**KIRKLEES METROPOLITAN COUNCIL
INVESTMENT & REGENERATION SERVICE**

DELEGATED DECISION TO DETERMINE PLANNING APPLICATIONS

Reference No:	2023/62/93706/W
Site Address:	4, Little London, Blackmoorfoot Road, Blackmoorfoot, Huddersfield, HD7 5PY
Description:	Erection of attached garage and porch
Recommending Officer:	Molly Storer

DECISION – Conditional Full Permission

Proposed front/south facing elevation (1:100)

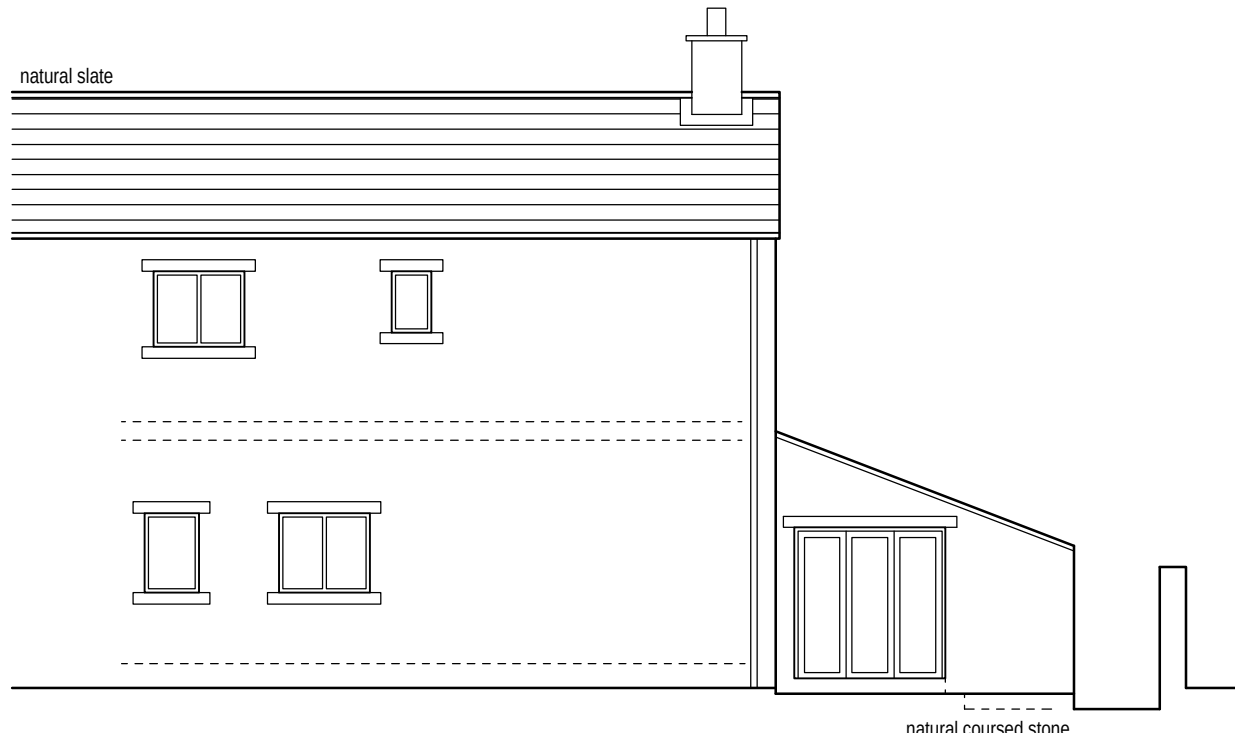
The proposed extension would project 4.1 metres beyond the south elevation of the host dwelling; therefore, it would not extend more than two thirds the width of the host property, in accordance with the design guidance as set out within the House Extensions and Alterations SPD. In addition, the extension would be significantly set back from the principal elevation, by 3.7 metres, and would be set down from the host roof pitch by at least 2.5m. For these reasons, the size/scale of the proposed extension is considered to be subservient to the host property of 4 Little London.

In terms of an overbearing or overshadowing effect to No.2, due to the design of the extension especially the lean-to roof and the low eaves height it is considered not to create significant massing. It is also noted that a 1.2m gap will remain between the development and the property boundary further lessening the impact of the extension. It is therefore considered not to cause significant residential harm to the residents at No.2 Pioneer Barn.

Proposed side/west facing elevation (1:100)

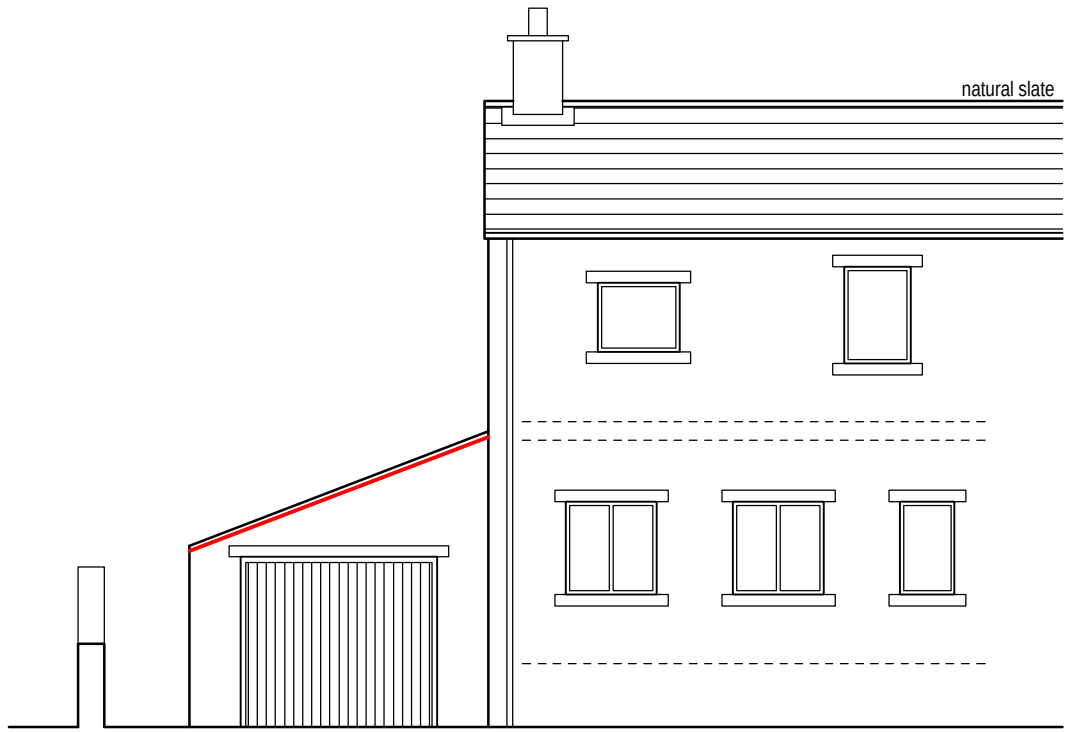
In terms of privacy to this property although there would be glazing in the form of bifolding doors on the west elevation facing Pioneer house this would be significantly set back from the west elevation. Due to the separation distance being over 12m between the bifolding doors and habitable windows in this neighbouring property it is considered no significant material harm would be caused to the privacy of the occupants.

Block plan (1:500)

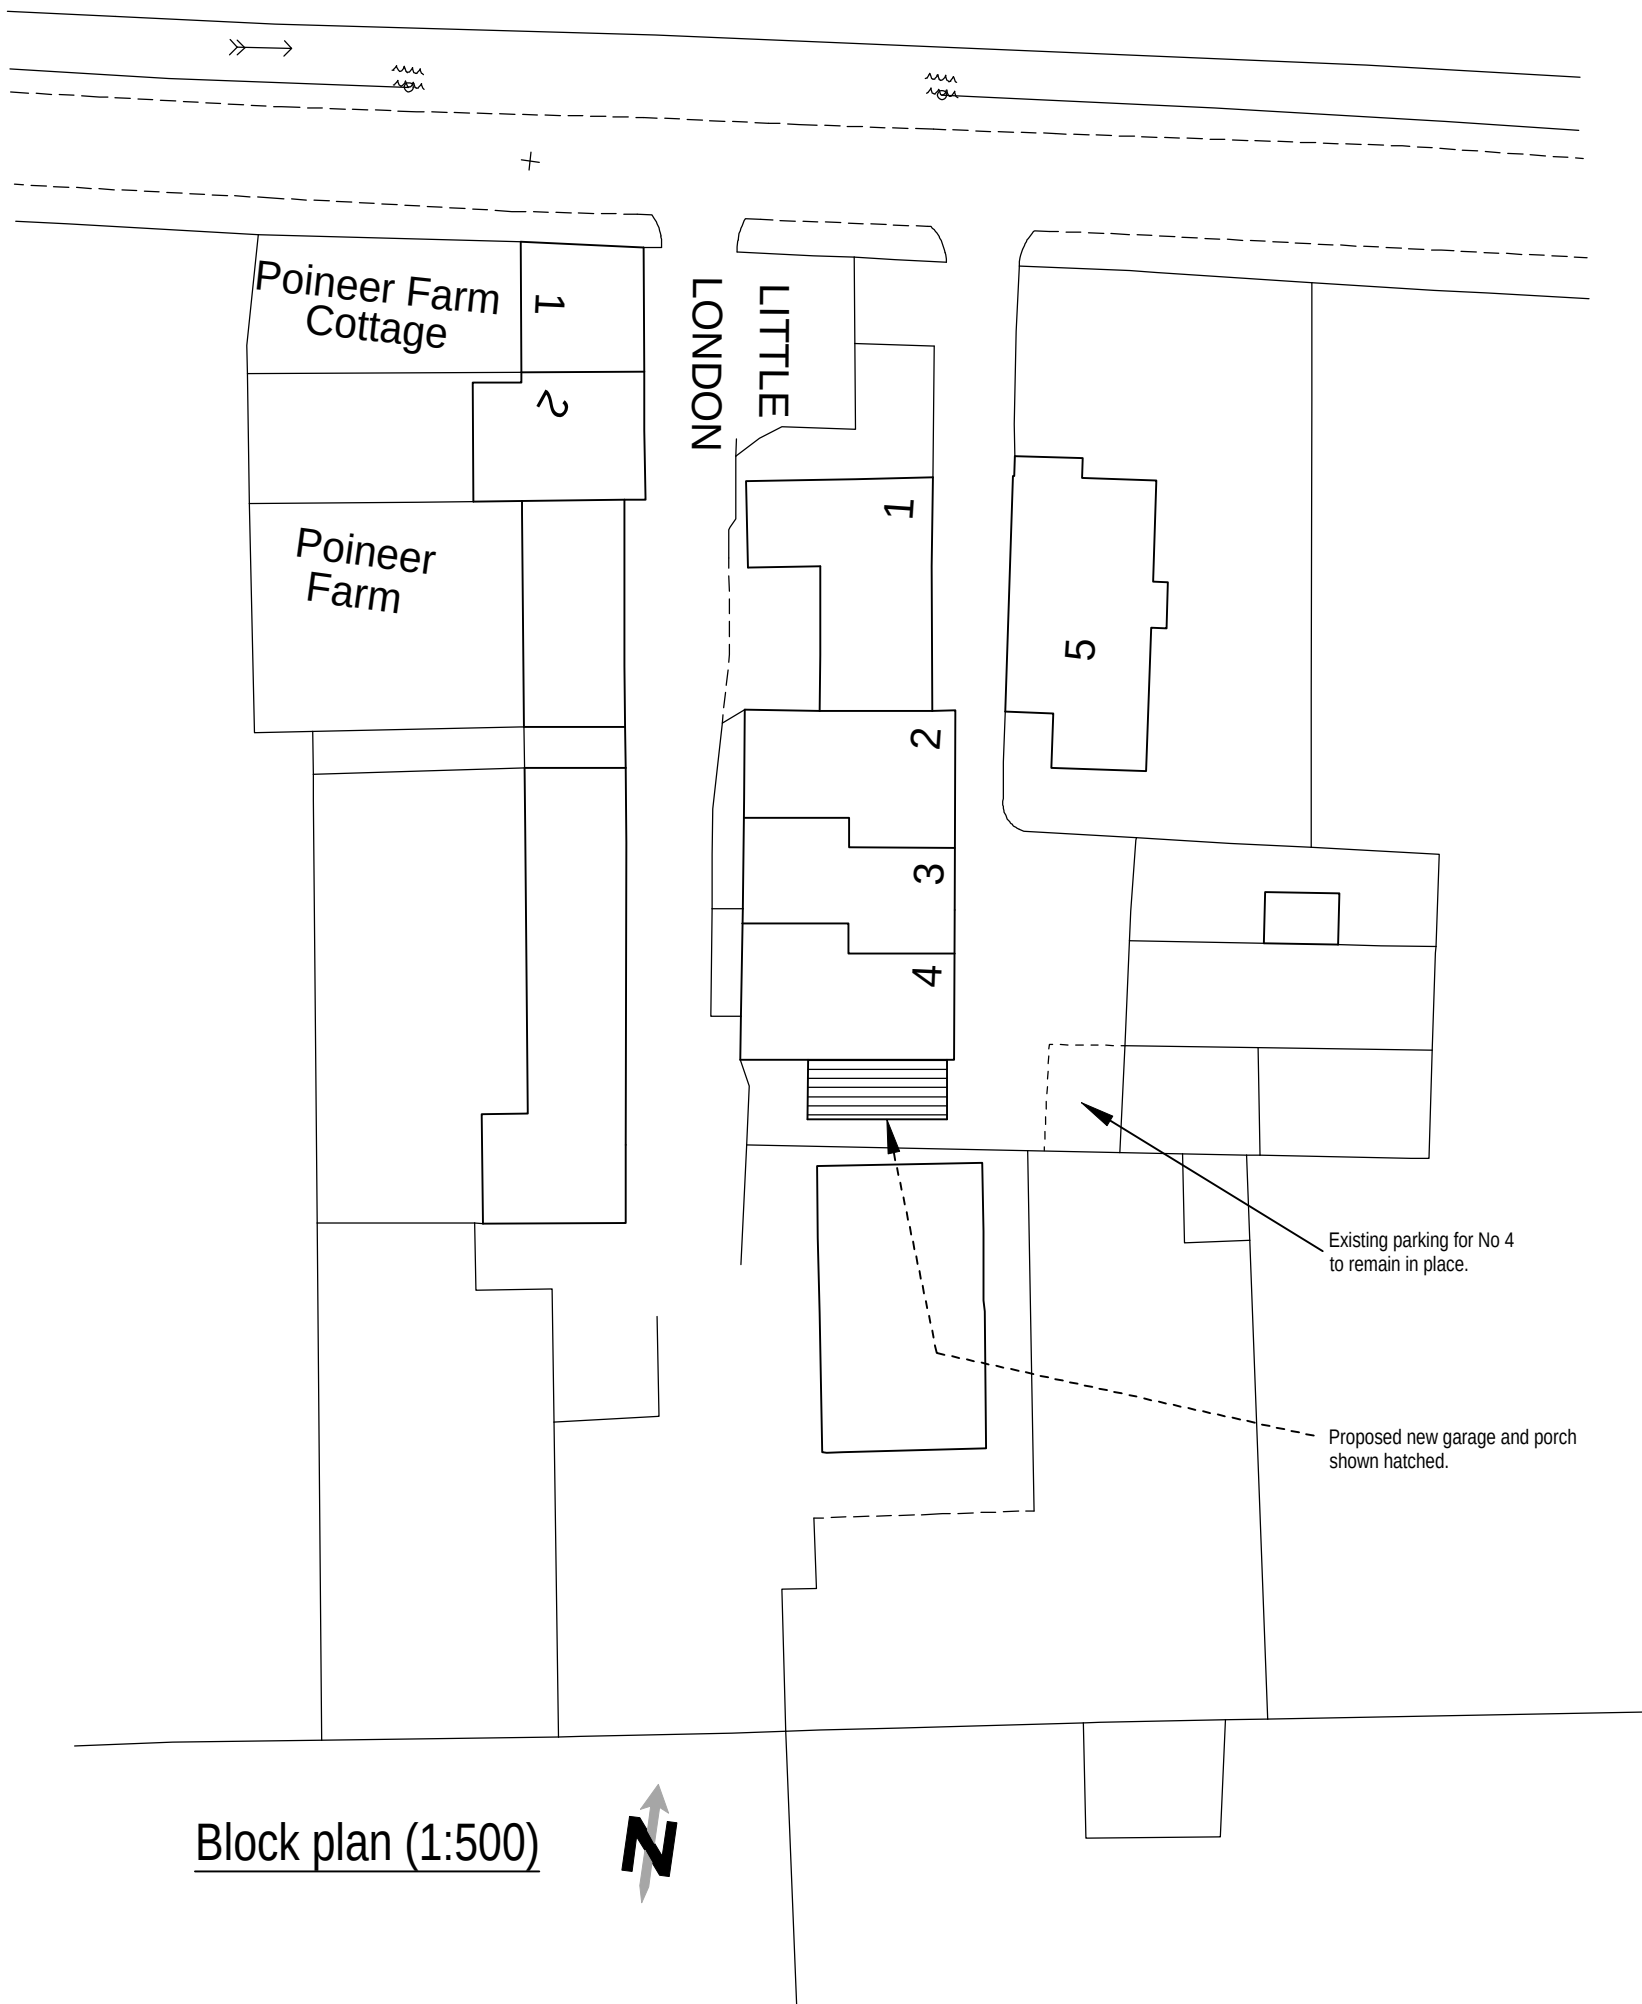
There were concerns raised about a previous, similar application at the site being refused due to it potentially removing turning space for the original development. The agent provided a justification statement and evidence that the area where the garage is located has not been used for vehicle turning ever since they moved in 6 years ago. From the site visit it is clear that there are opportunities for the parking of vehicles, with limited turning, elsewhere on site. In addition, since the refusal of planning permission the agricultural building to

The application proposes no increase to the number of bedrooms at the site. It should be noted that there is generous space within the site for parking opposite the property. It is therefore considered that the proposal is likely to have a neutral impact upon the safe and efficient operation of the highway network.
